**Our Ref: HB/KN/0051/18**

**Application for Non-Material Amendment to Planning Permission P23/00568/F  
Land at Harlequin Office Park, Fieldfare, Emerson Green, Bristol BS16 7FN  
Planning Portal Reference PP-**

The application seeks to vary condition 2 which references the approved drawing and secure a number of minor non-material alterations to the scheme.

DRAWING DESCRIPTION
PROPOSED GREGGS FLOOR PLANS (PLANNING)

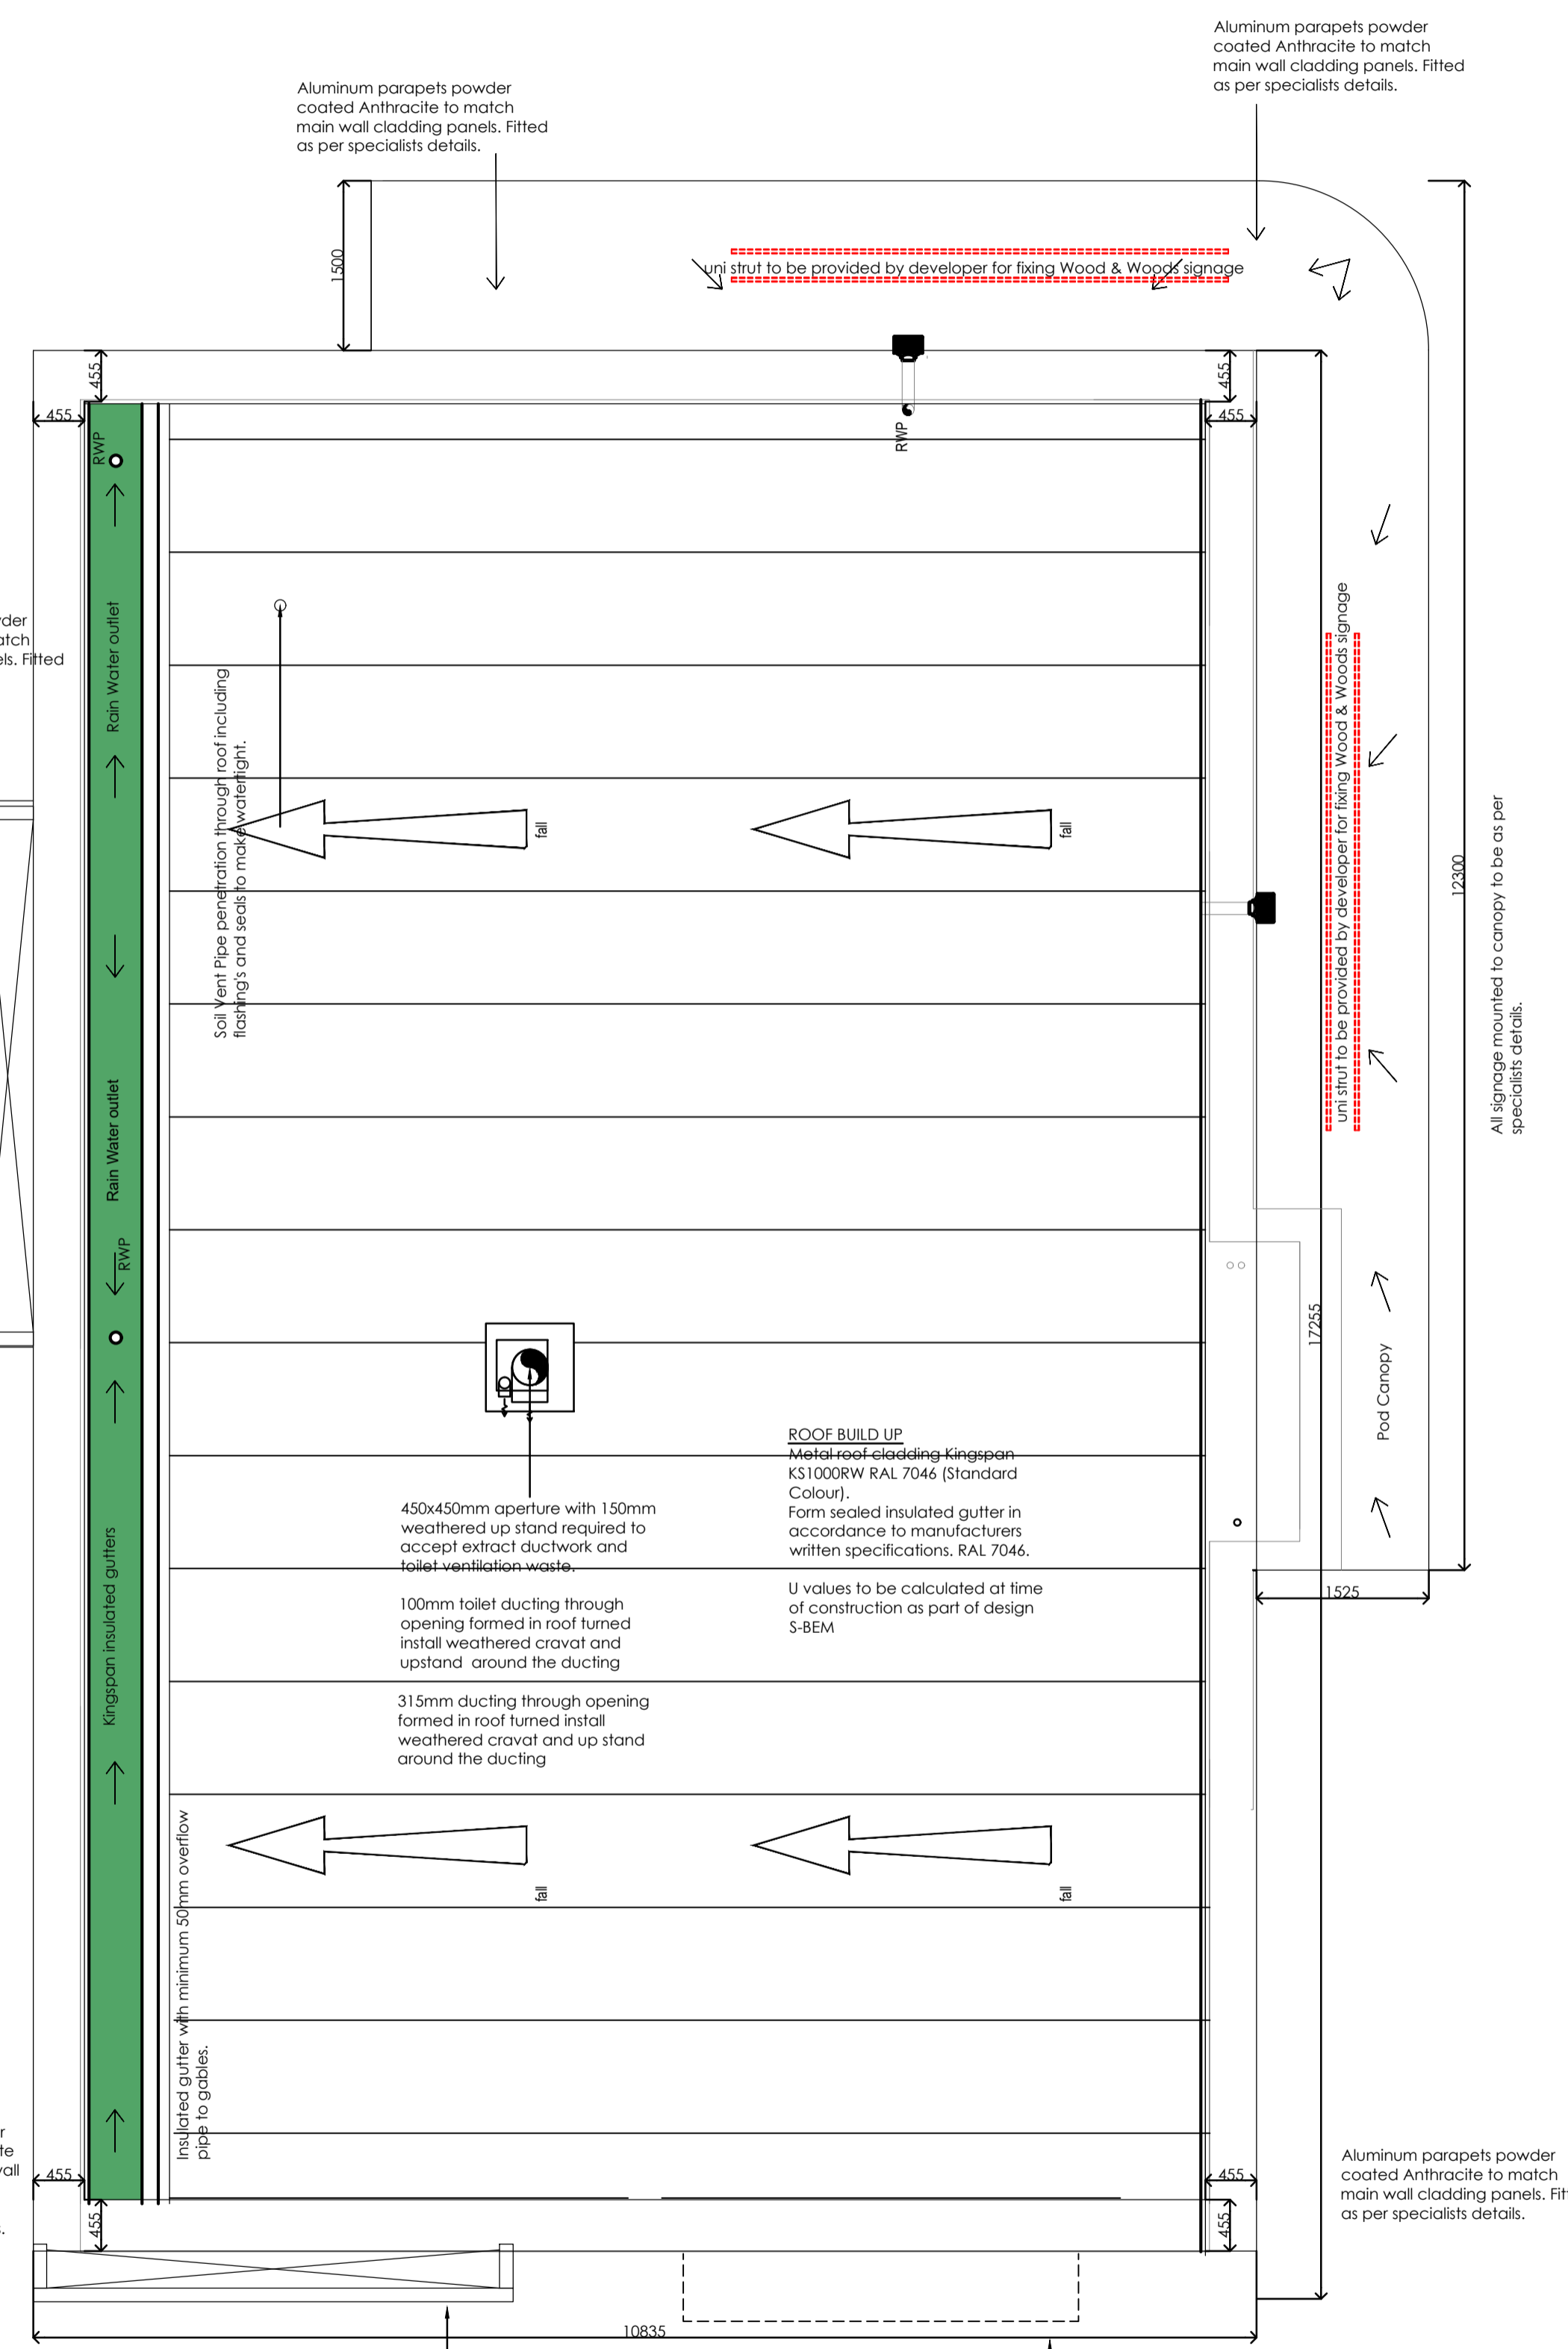
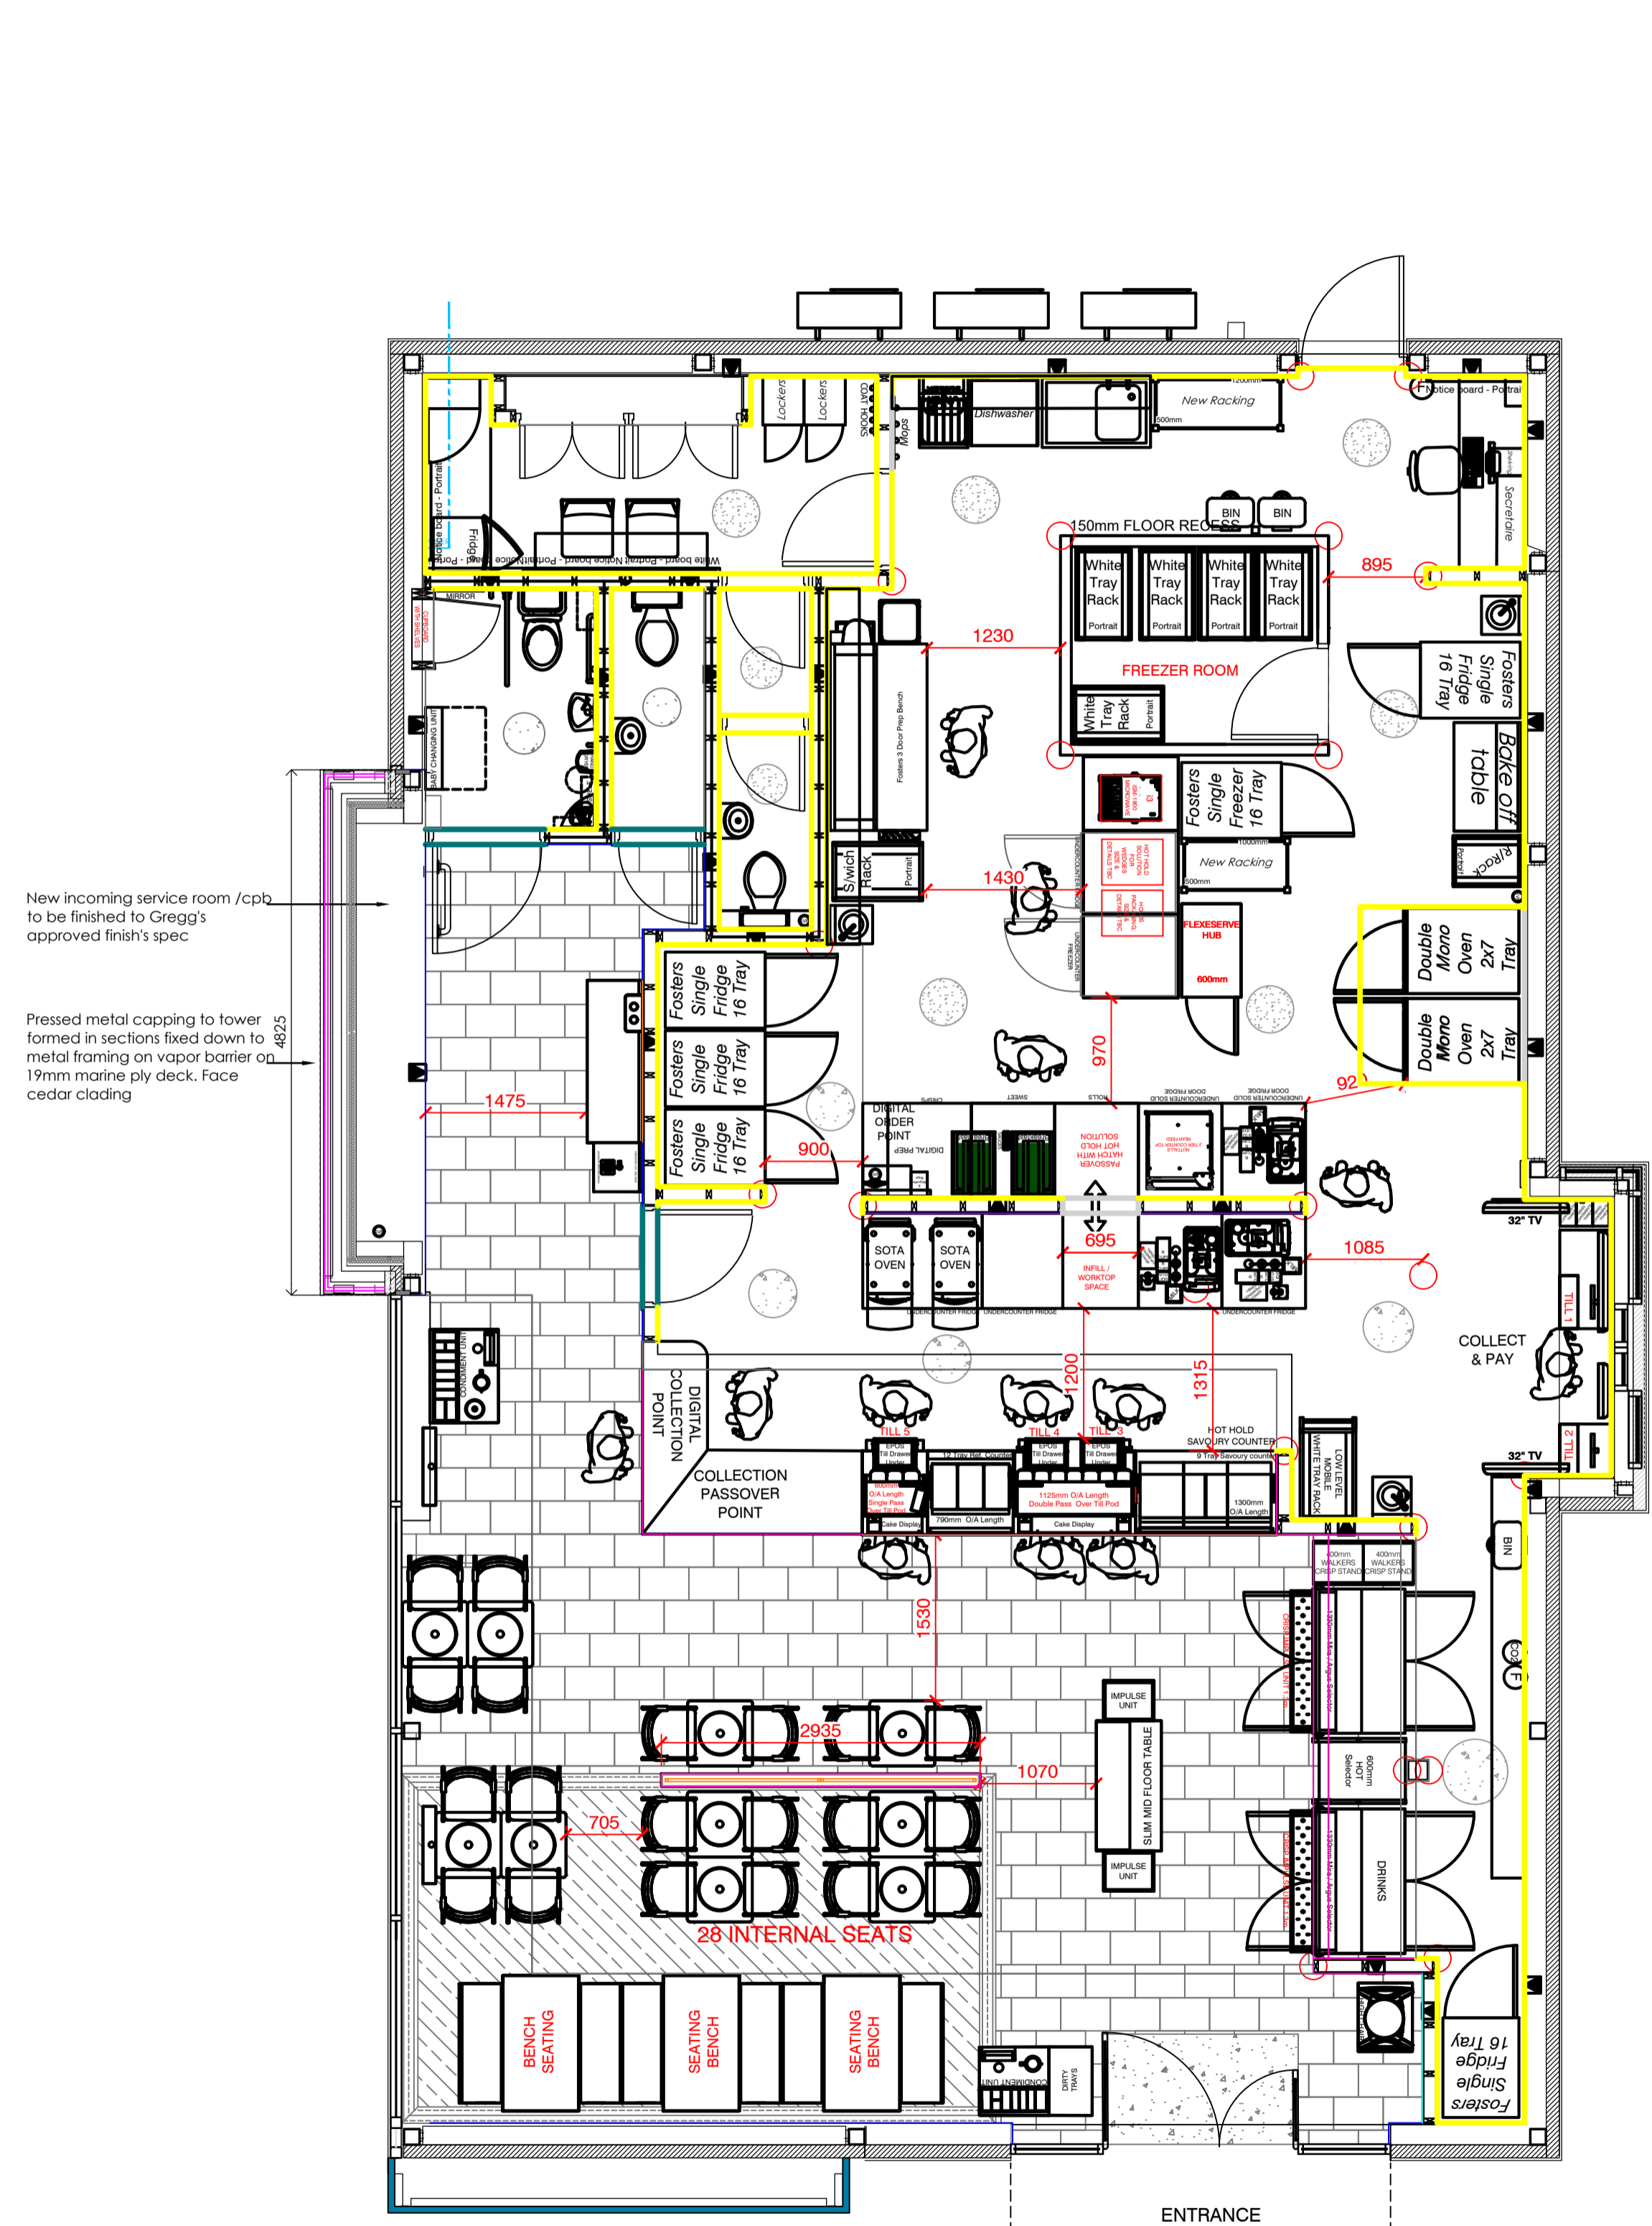
- Replacement of a door with four panel glazed window on side elevation and omission of canopy. A secondary entrance is no longer required.
- Addition of glazed canopy over the main entrance door to provide cover from inclement weather.
- Creation of utility cupboard within cedar cladding projection side elevation.
- Rationalization of utility kiosks at the site entrance.
- Minor increase in the height of the fence around external plant compound and bin store from 2.4 metres to 2.5 metres to better secure and screen the service area.
- Addition of small ventilation grill to the rear elevation of the Greggs unit.
- Addition of a vent to the roof
